MEMORANDUM

DATE: November 28, 2022

SUBJECT: On-Call Contract #17-067H-1; PO # 8115428
Traffic Impact Study Reviews
TO #10: Owl Place Commercial Traffic Impact Study (CR221)
Second Review

This memorandum includes a list of comments on the September 2022 Owl Place Commercial Traffic Impact Study (TIS) (revised from June 2022) prepared by SM Rocha, LLC for First Cup. Our comments are based on requirements provided in the County's Engineering Criteria Manual (ECM), Appendix B.

**Figure 2**  
**CONCEPTUAL SITE PLAN**  
 January 2023  
 Page 4

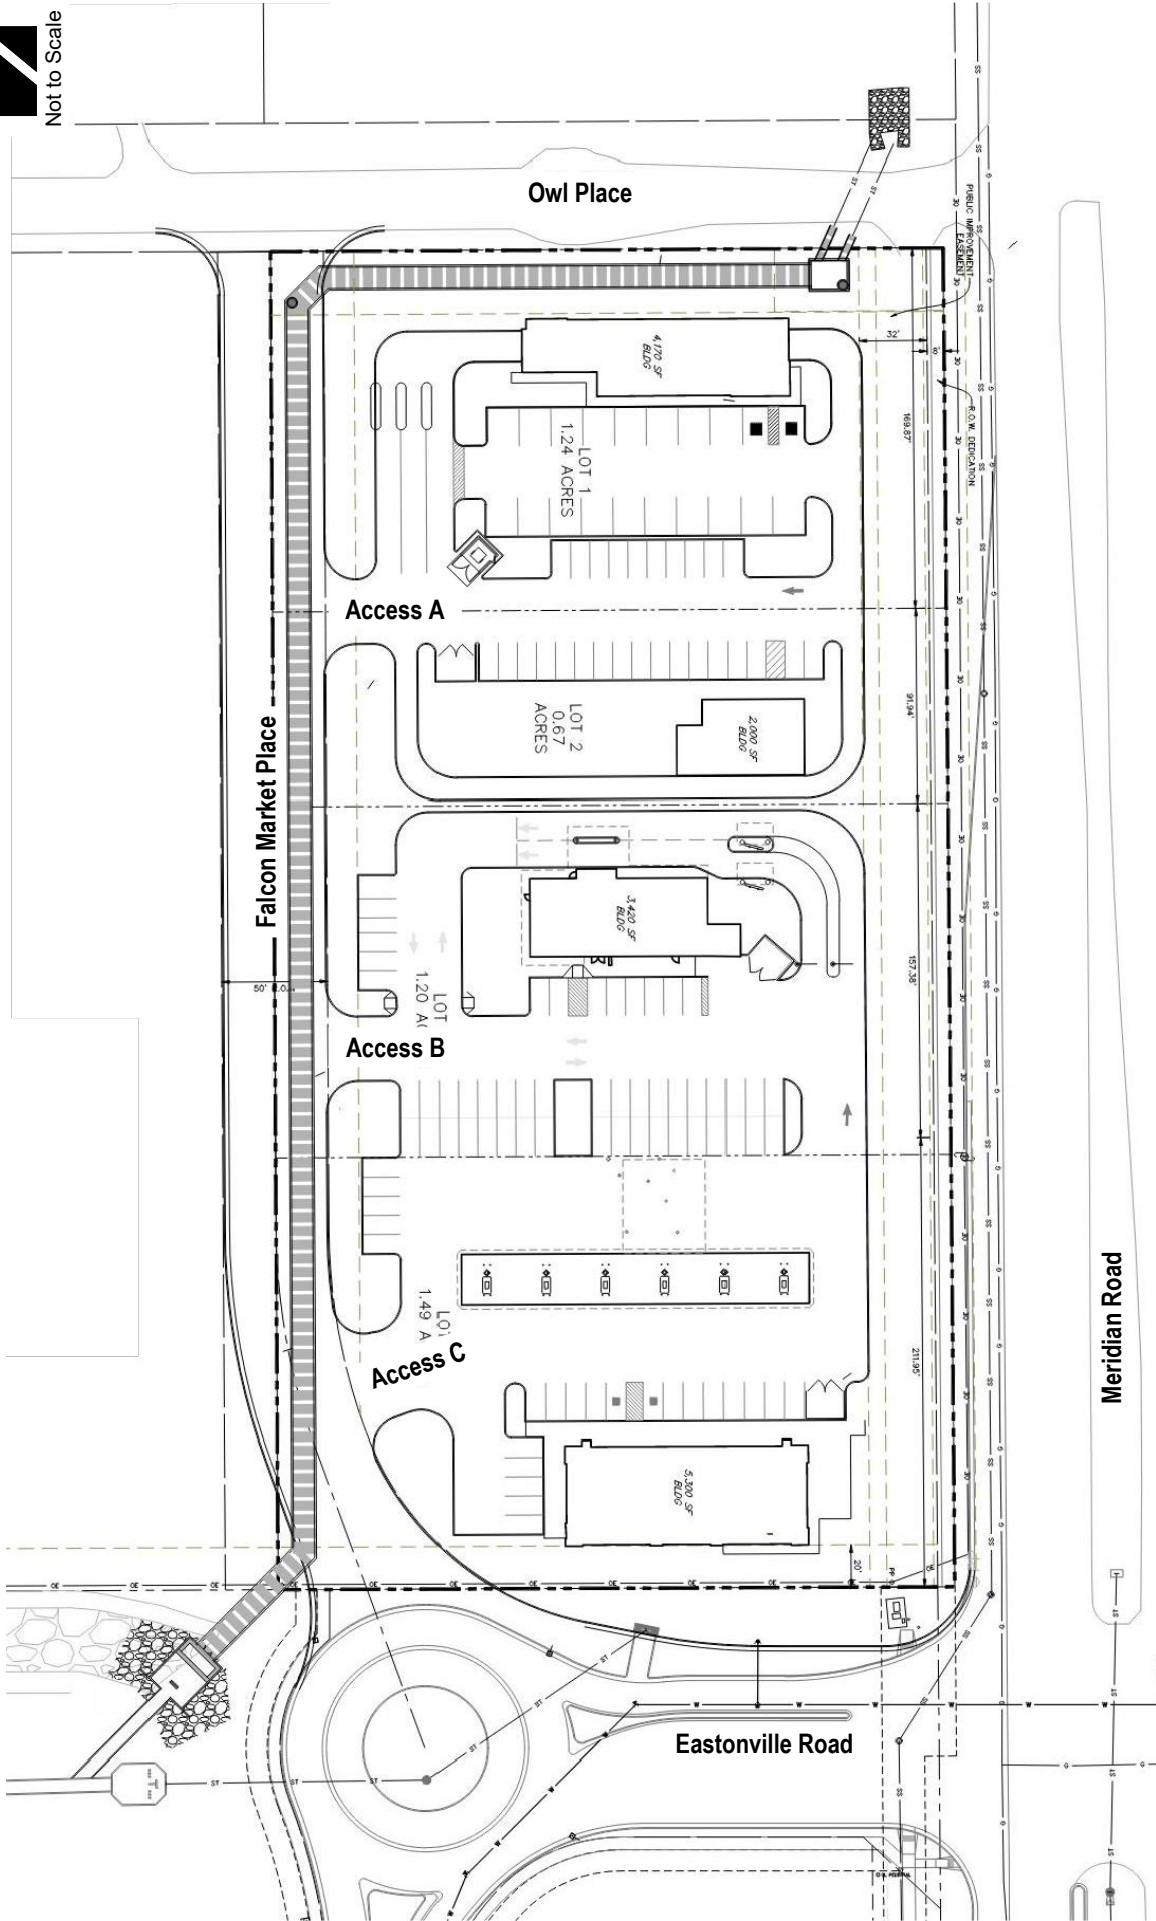
1. Figure 2, the Site Plan, shows that three driveways along the north-south spine roadway are anticipated. This is likely an improvement when compared to the site plan presented in the previous TIS. However, these accesses have not been analyzed for traffic volumes, LOS, or queuing. Potential queuing into the northernmost driveway from Lot 1 or Lot 2 could impact traffic operations at the access road intersection at Owl Place (Access A).
